From: Amanda Scholes on behalf of Planning.Responses
Sent: 04 August 2020 10:17
To: Planning Scanning
Subject: FW: A/83/20/PD - 1 Marsh House, the Square, Angmering

From: Nina Sidhu <Nina.Sidhu@arun.gov.uk>
Sent: 15 July 2020 11:41
To: Andrew Wood <Andrew.Wood@arun.gov.uk>
Subject: A/83/20/PD - 1 Marsh House, the Square, Angmering

EH has **no objection** in principle, but the following specific issues would need addressing before first use as A3:

JUNA HOME AND GARDEN
1 MARSH HOUSE
THE SQUARE
ANGMERING
WEST SUSSEX
BN16 4EA

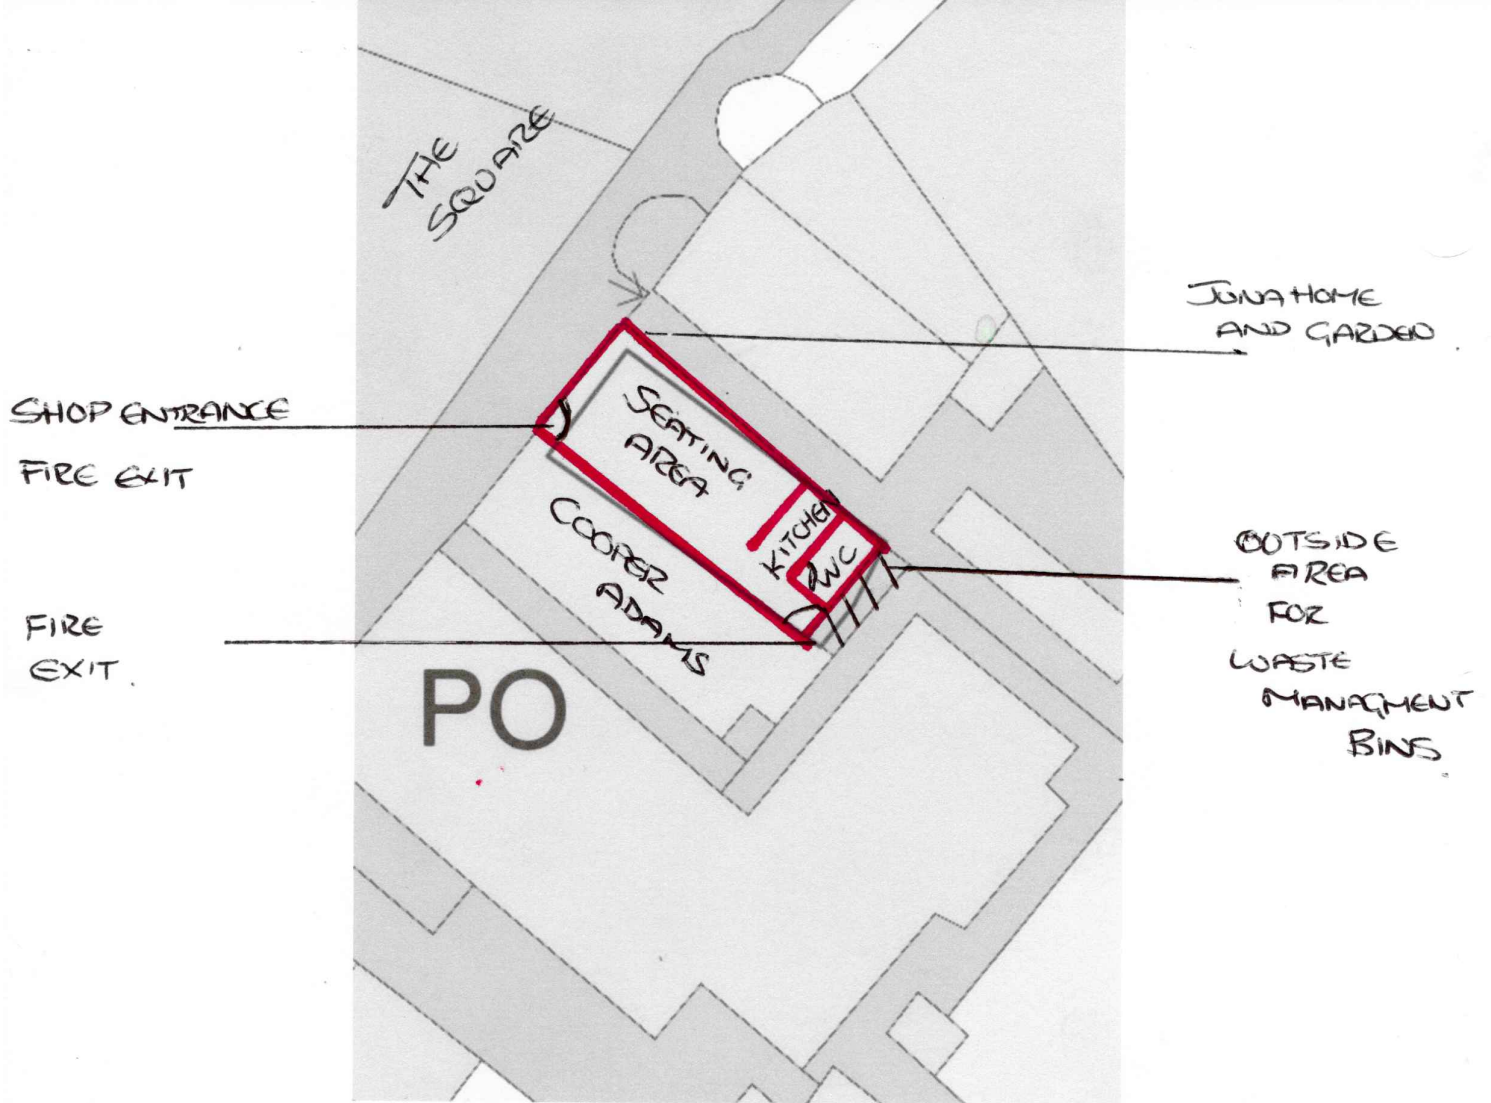
The layout plan indicates a toilet opening onto the kitchen/food handling area without an intervening lobby, which does not comply with food hygiene requirements. Also sanitary provision must be considered for staff and customers. Please see below under Informatives.

8. The proposed floor plan currently shows one toilet in the premises. The numbers of toilets required will depend on the number of staff and seated customers proposed. Any customer toilets provided must not be accessed via the kitchen or any food handling areas. Please note the requirements for toilet provision in Arun District which can be found at <https://www.arun.gov.uk/download.cfm?doc=docm93jjm4n11788.pdf&ver=11779>
9. The granting of this planning permission does not in any way indemnify against statutory nuisance action being taken should substantiated complaints within the remit of the Environmental Protection Act 1990 be received. For further information please contact the Environmental Health Department on 01903 737755
